Fire Protection Report & Wildland Fire and Hazard Mitigation Plan

Berisfod 4-Lot Subdivision

Preparer:

SHEET 1 OF 2

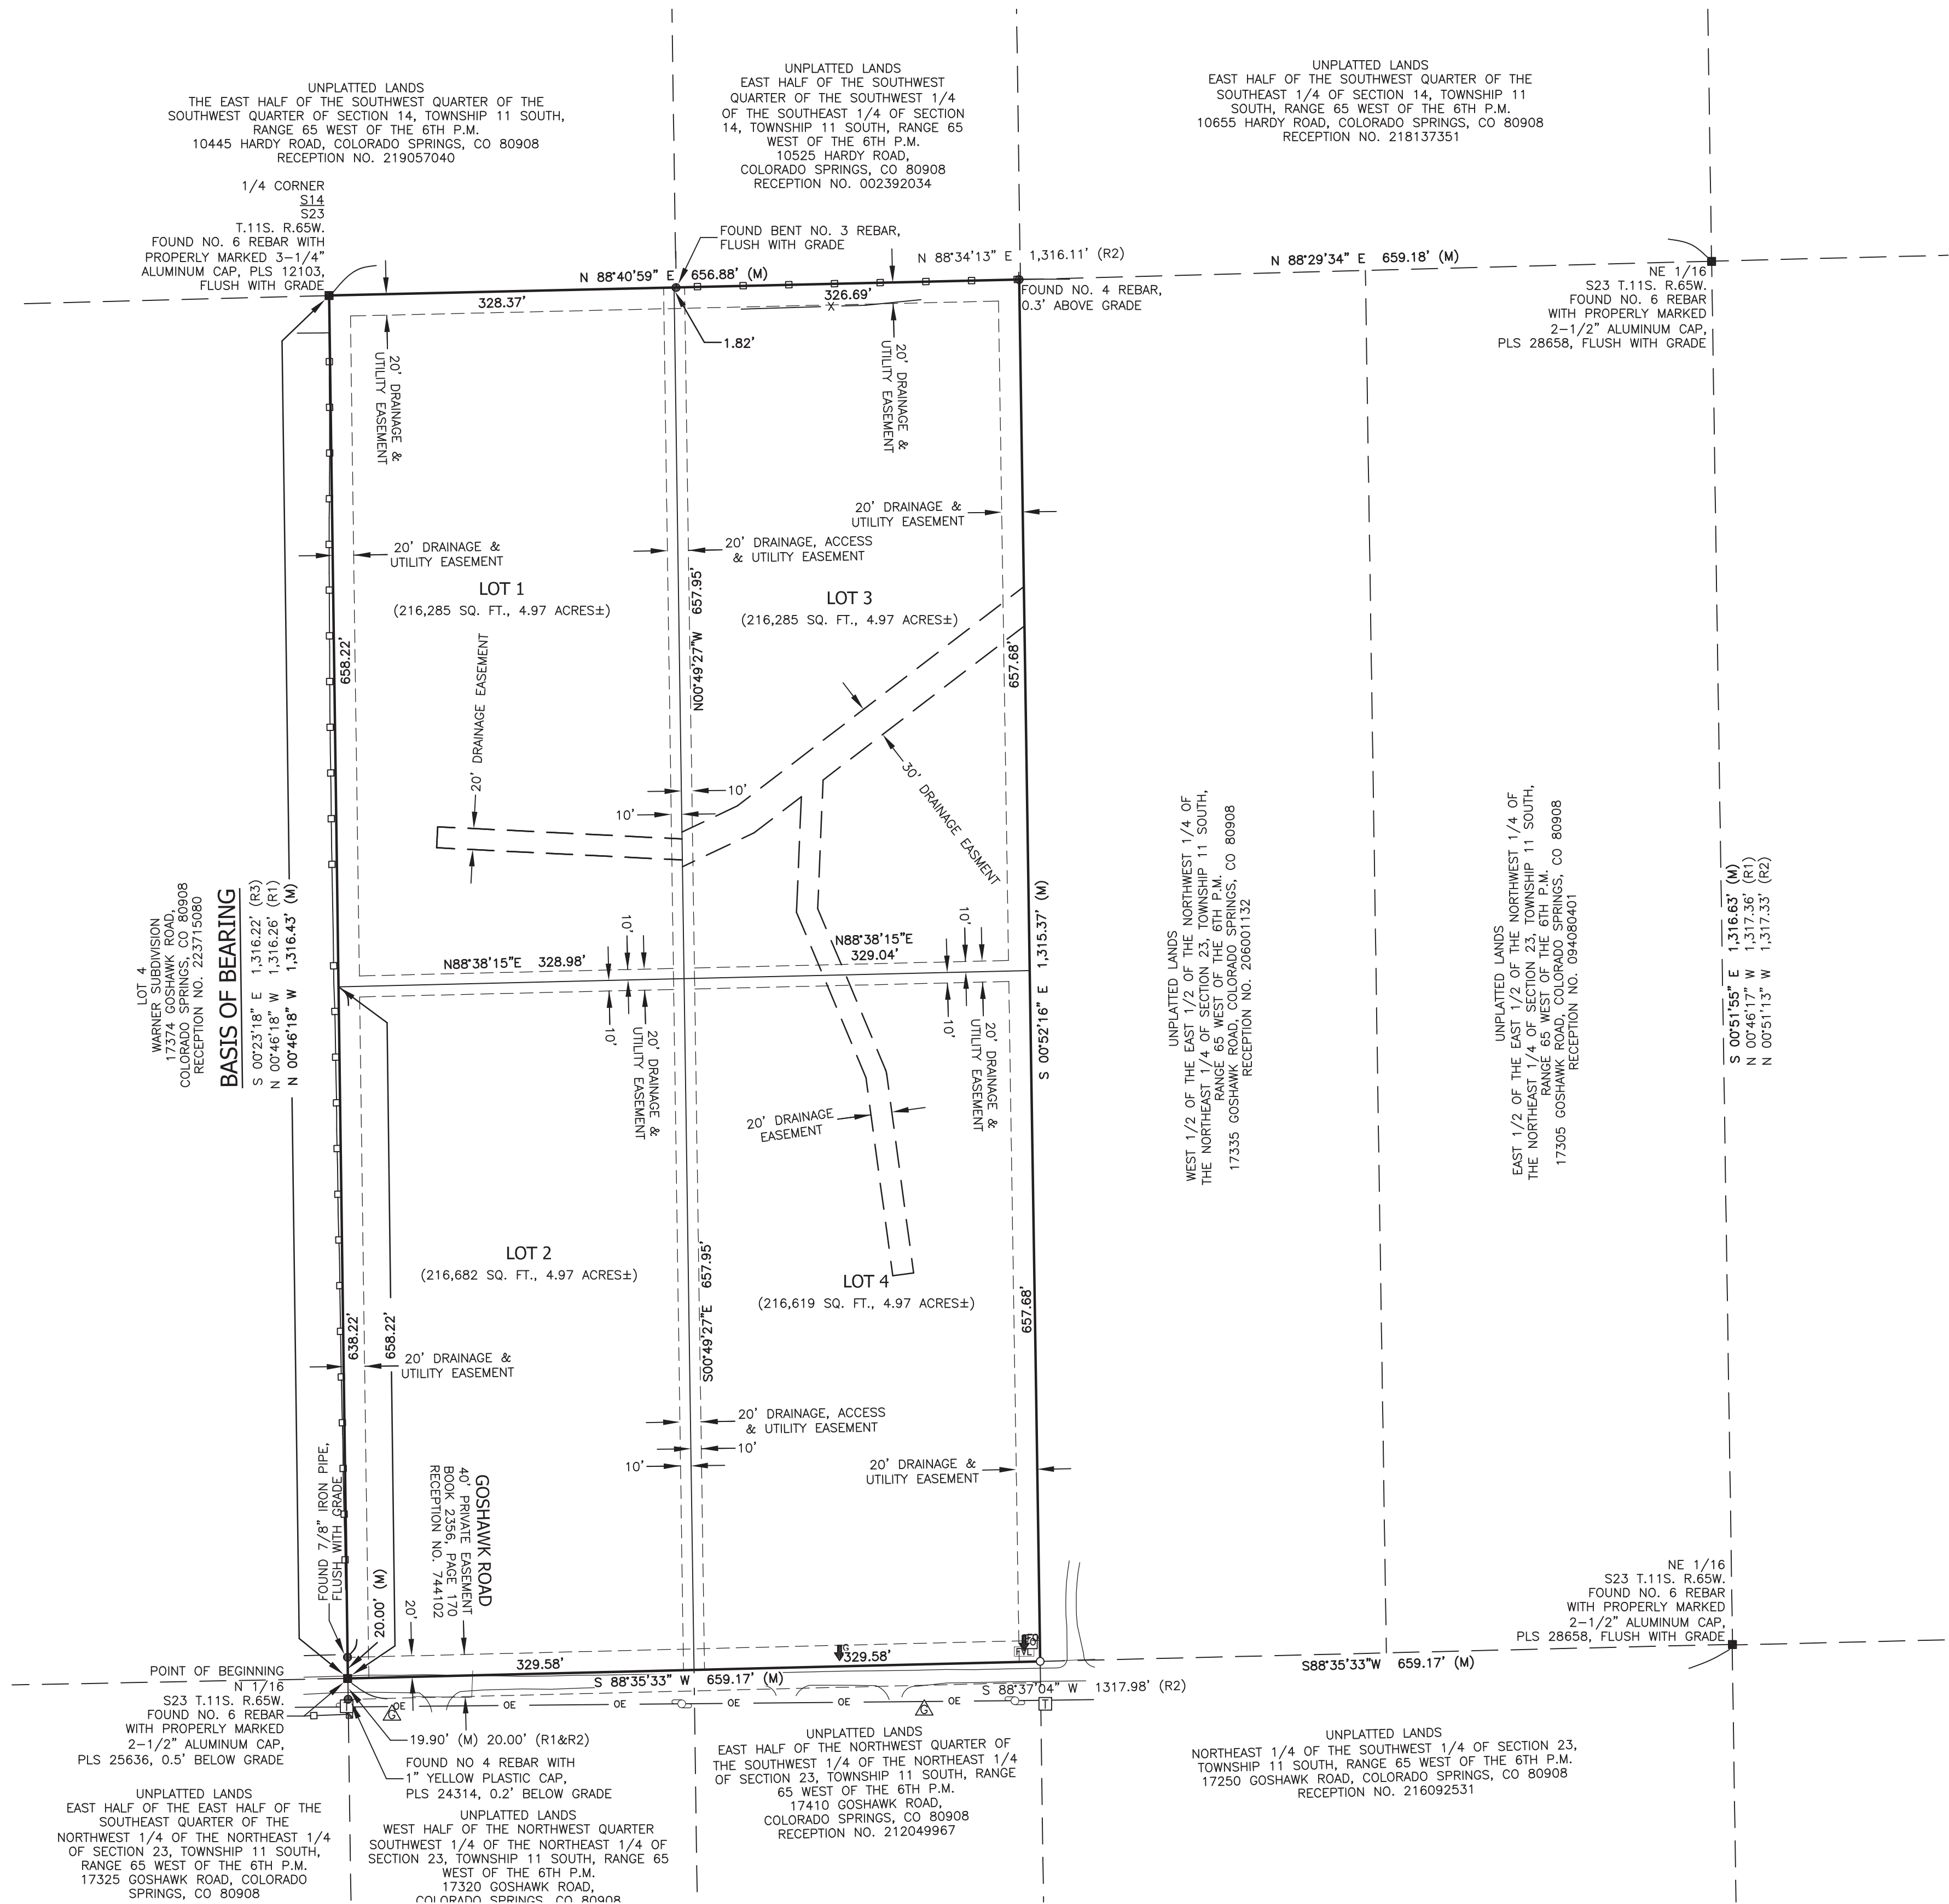
Will an updated fire turnaround easement be added?
